Necton Parish Council (NPC) Final Boreas Representation

Necton Parish Council
7 October 2020

Analysis of Core Strategy and Development Core Strategies Not Followed with Respect to the Proposed Vanguard and Boreas development Projects

Title:	Scenario 1 Viewpoint 4: A47 Necton Substation
--------	---

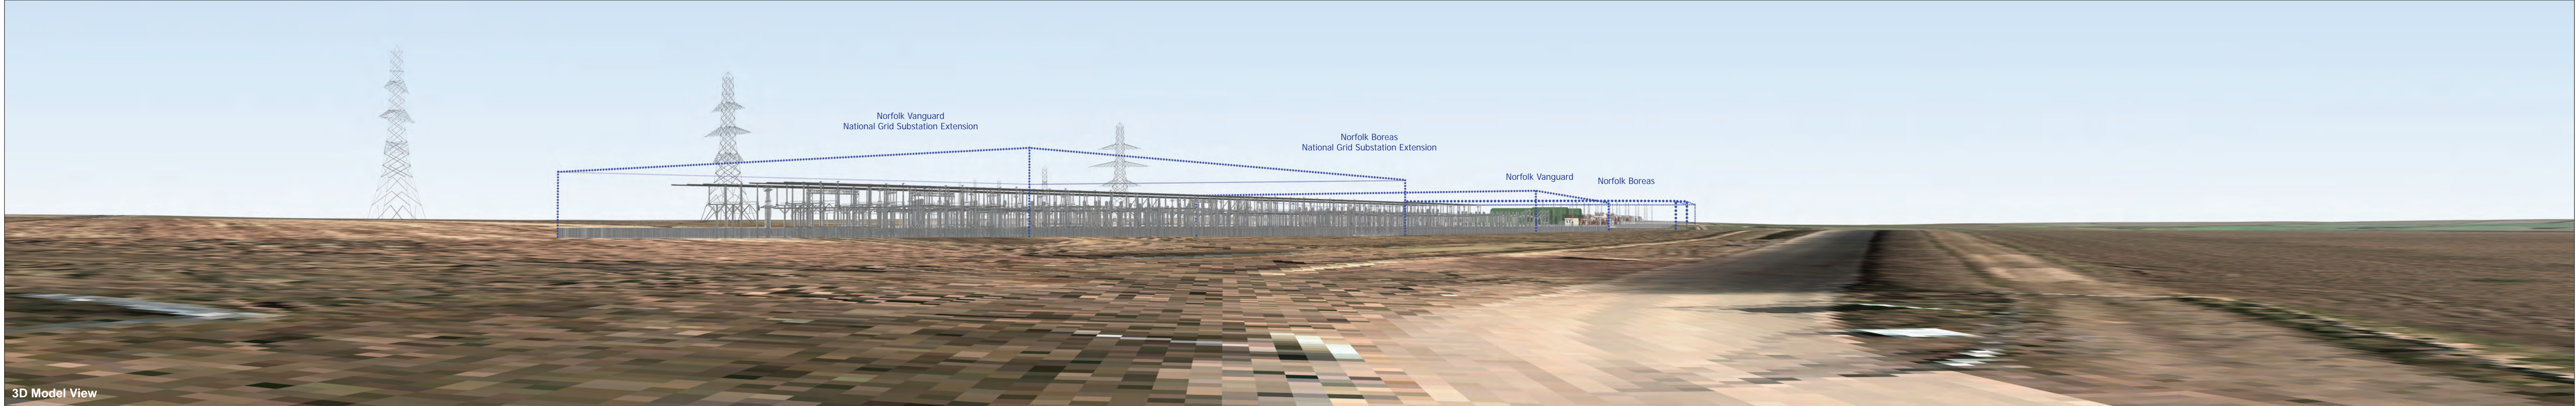
We ask the examining authority to require an alteration to the Boreas DCO such that the mitigation suggested by Necton Parish Council and the Necton Substation Action Group of 10-metre-high earth banks covered with mature trees is implemented by the project.

The proposed Vanguard and Boreas substations are huge buildings and are planned to be erected on the highest land in the area. This will have a significant effect on the surrounding landscape. Necton Parish Council and the Necton Substation action Group (local residents) all made representations to the Vanguard and Boreas Examining authorities both orally and in written form objecting to the effects on the rural landscape that will not be effectively mitigated. They also met with the designated Breckland Council representative to ensure Breckland were aware of their concerns and the mitigation measures they would consider to be adequate. The cumulative effect of Boreas and Vanguard together has not been considered by Breckland or the Examining Authority during the Vanguard examination but should have been and will at least double the adverse effect on the landscape. These are sister projects using the same ductwork, adjacent National Grid connection and substation sites so their cumulative impact was obvious from the beginning of the consultation process.

Necton Parish Council support renewable energy but would like it to be installed with adequate mitigation. The mitigation we requested is the same as that which has already been built along the Northern distributor road between Necton and Norwich. Breckland Council should, in our opinion, have been supporting our request for this mitigation in their SofCG and did not. The Breckland procedures call for adequate mitigation and have not been followed during the consultation and examination process.
